From: Nicola Spencer on behalf of Planning.Responses
Sent: 12 December 2025 19:14
To: Planning Scanning
Subject: FW: Planning Consultation on: BR/194/25/DOC

Application No:	BR/194/25/DOC
Registered:	6th November 2025
Site Address:	Bognor Regis Football Club Nyewood Lane Bognor Regis PO21 2TY
Description of Works:	Approval of details reserved by condition imposed under BR/236/24/PL relating to condition 4-surface water drainage scheme.

REVISIONS
PROPOSED DRAINAGE LAYOUT

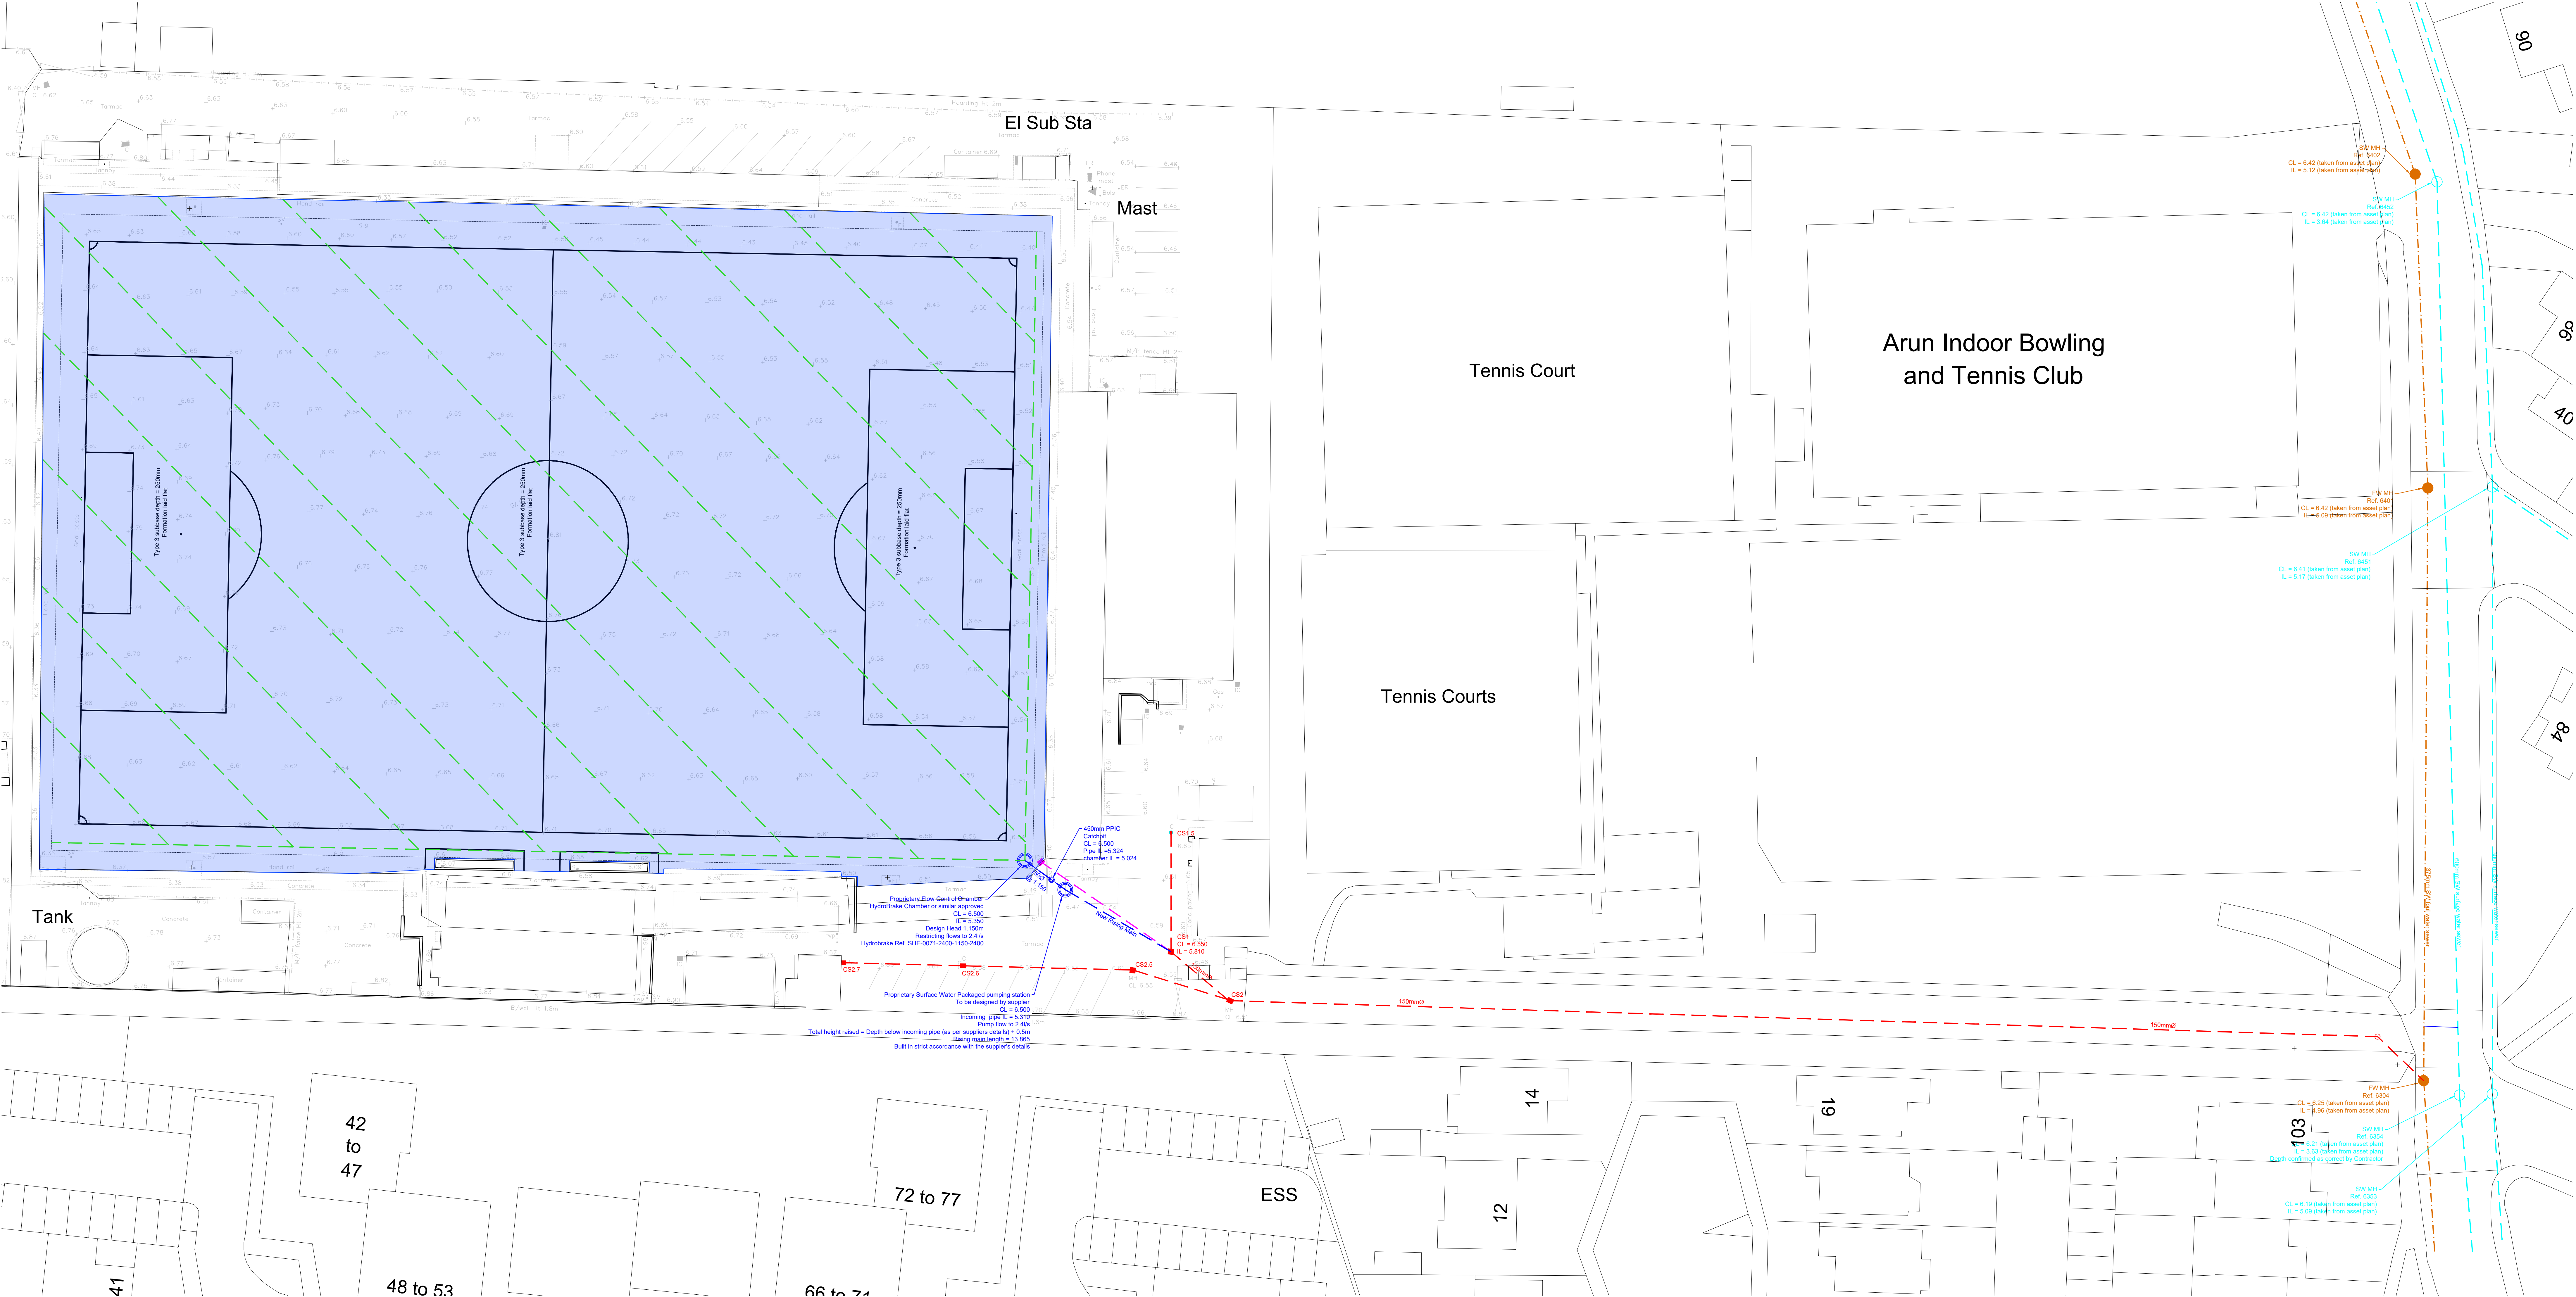
Since this current proposal replicates the original ‘unacceptable’ scheme, I have no option but to ‘**OBJECT**’.

The current proposal is to discharge (via pumping) surface water runoff from the football pitch into the foul sewer network.

The NSfS does not consider discharges of surface water to foul sewer networks as a recognised option, for good reason (ie. pollution and flood risk). This requirement is irrespective of whether the site discharges surface water to the foul sewer network currently. As there is a public surface water sewer network available in Nyewood Lane, it is unclear as to why the site currently drains surface water to the foul sewer. Nevertheless, for clarity extracts from the NSfS detailing the hierarchy for surface disposal options is below;

Clause 1.10 - Surface water runoff from the development shall not discharge to a foul drainage system.

The proposals also intend to pump surface water rather than gravitate, due to the fact that they are connecting to a shallow foul drain. Connecting to the surface water sewer network would eliminate the need for a pump. Pumping is unsustainable and is appropriately discussed in the NSfS as extracted below;

Clause 1.24 The use of pumping within surface water drainage systems shall be by exception only and agreed with the approving body due to the associated carbon, energy and maintenance implications, and the risks associated with failure and exceedance.

Clause 1.26 Pumping shall only be utilised for any parts of the development that cannot be drained by gravity.

Therefore, any departure from the NSfS would need to be agreed by the Local Planning Authority, but deviation in this case would not be supported by ourselves, on grounds of pollution/flood risk. This is irrespective of whether flows to the foul sewer network are being reduced, as there is an alternative suitable disposal option available, which is in accordance with the hierarchy (ie. Priority 4). This would involve connecting to the Public Surface Water Sewer in Nyewood Lane.
